T1.3

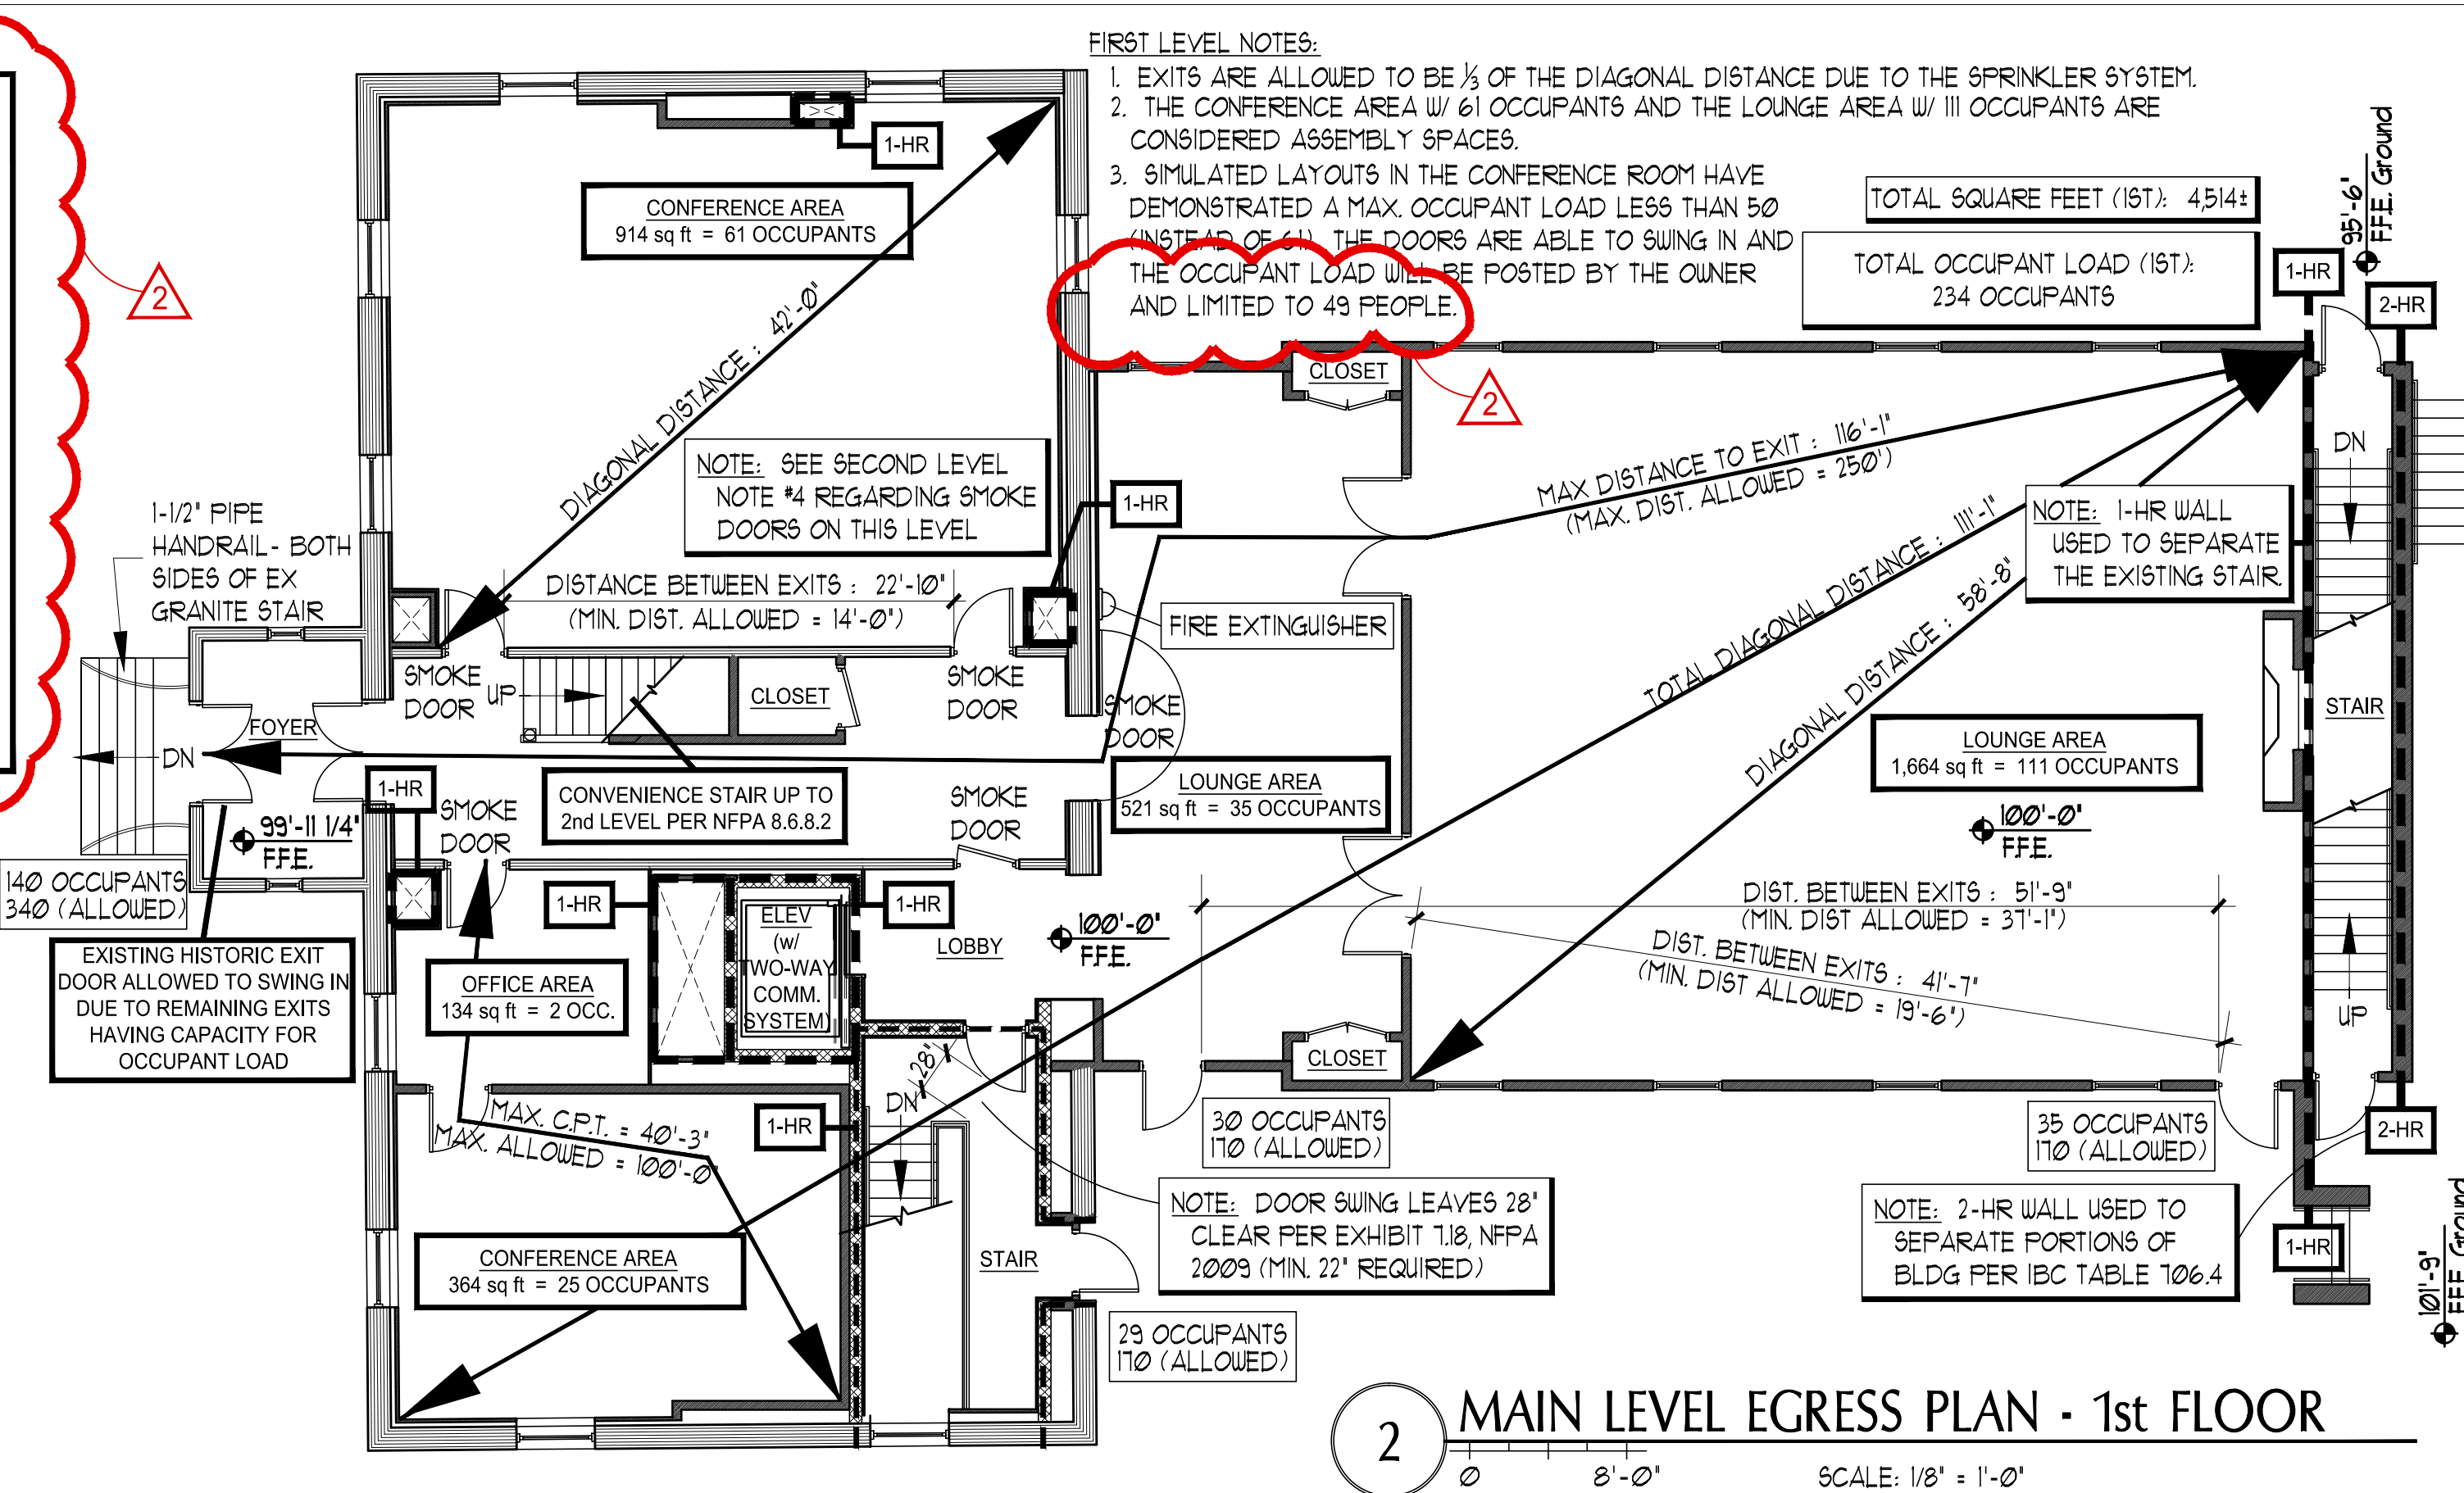
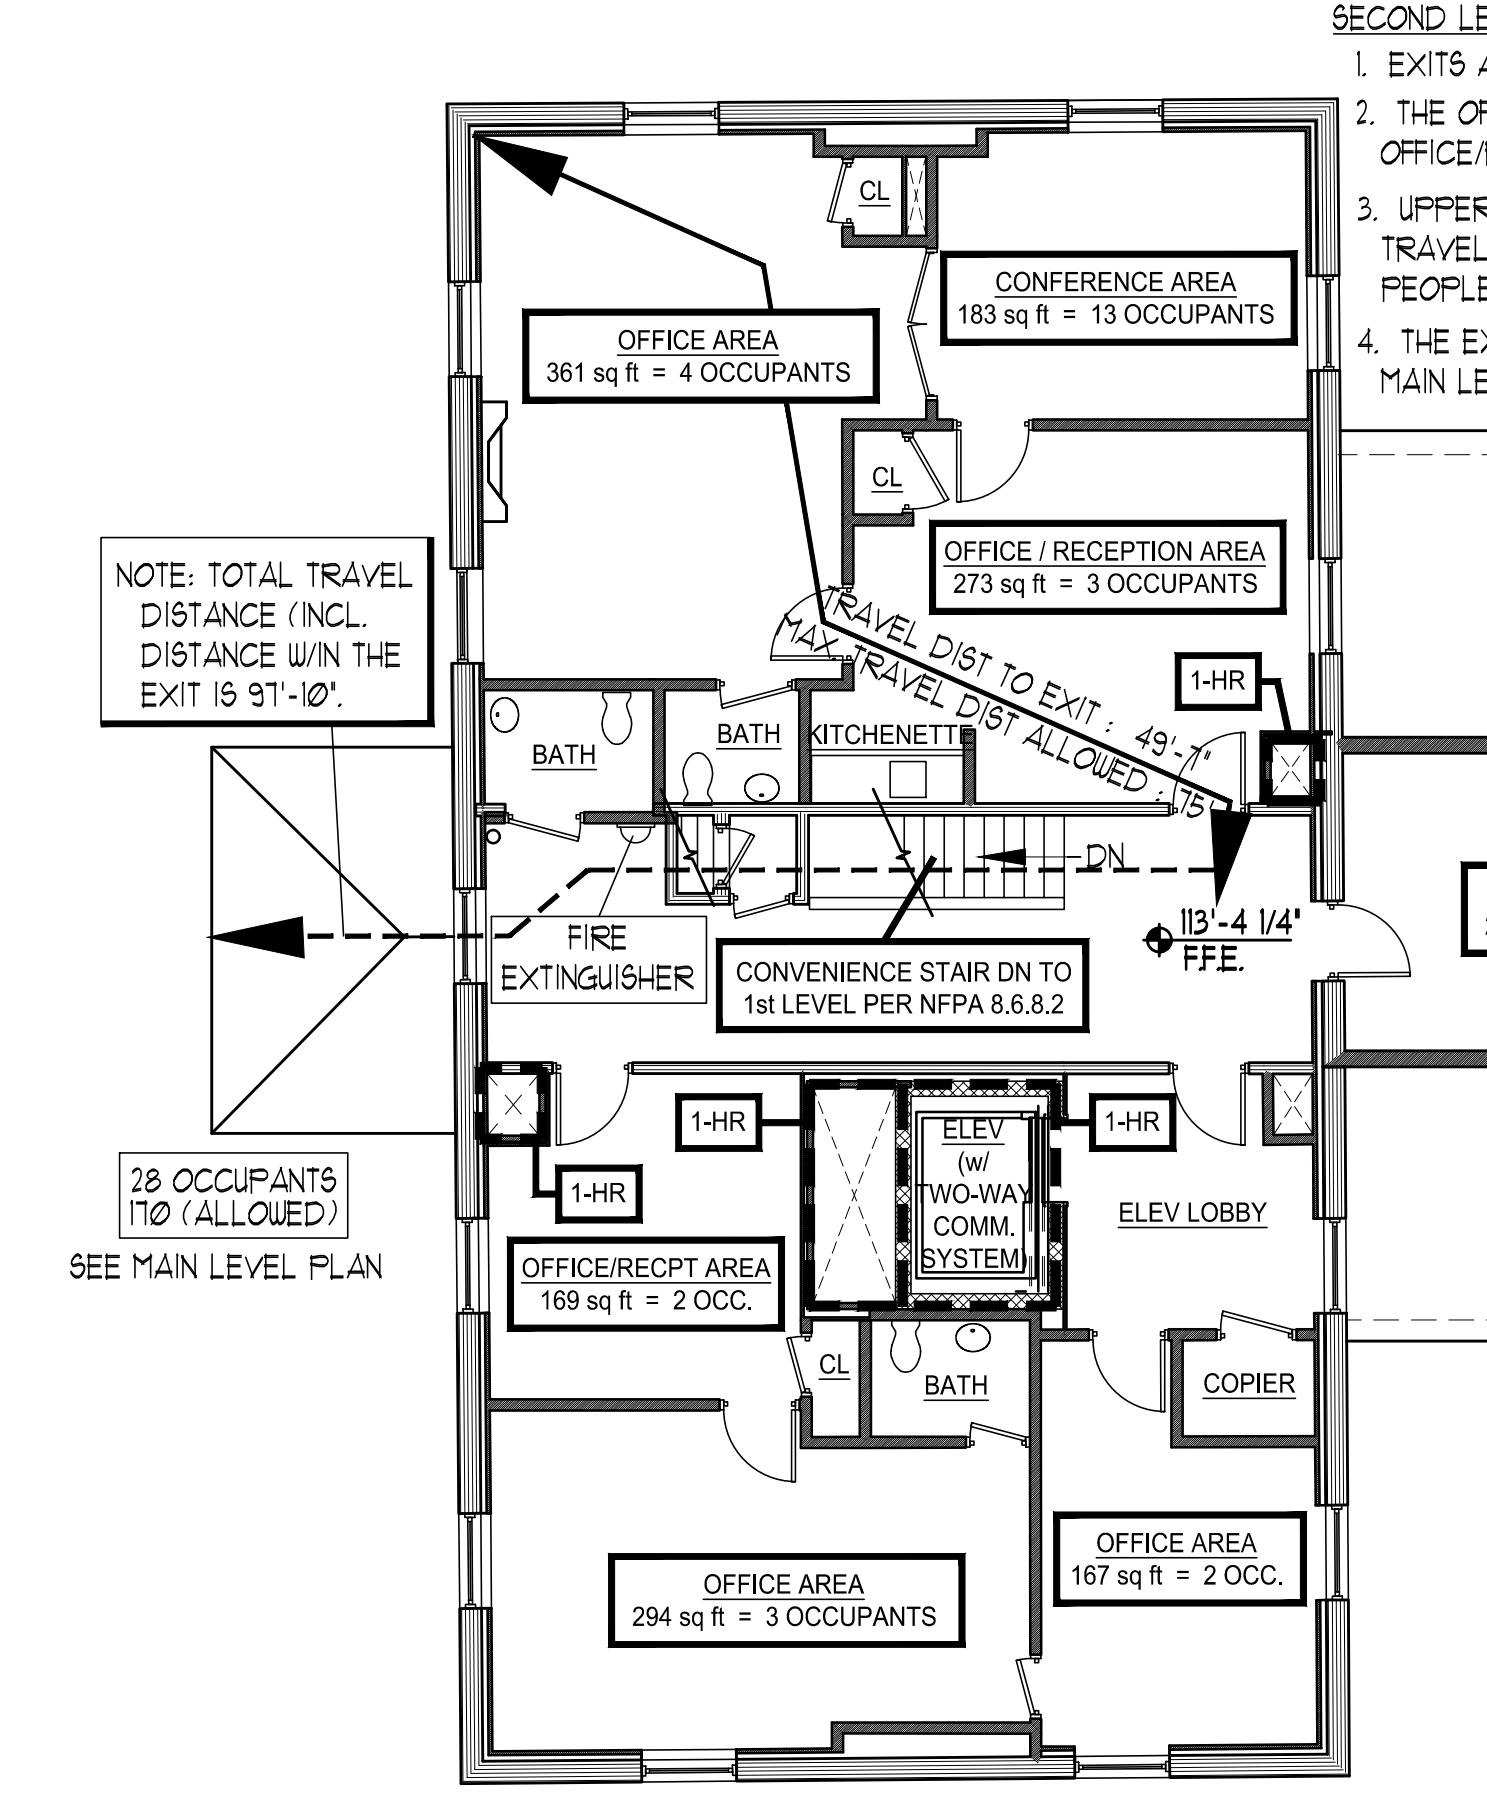
**Code Review - IBC 2012** Please confirm there are no contradictions with the adopted code, IBC 2009  
**Chapter 3 - Use and Occupancy Classification**  
**Section 303.1** - This building is classified as Assembly (A-3).  
**Section 304.1** - This building is classified as Use Group B (Business).  
**Note:** Due to the intermingling of the uses, this will be a Mixed-Use, Non-separated building. See Section 508.3.

**Section 1028.3** - The other exits (not the main exit) shall also accommodate 1/2 of the total occupant load (34.6" minimum).  
**Please provide a code review per the UPC 2009 for plumbing fixture requirements**
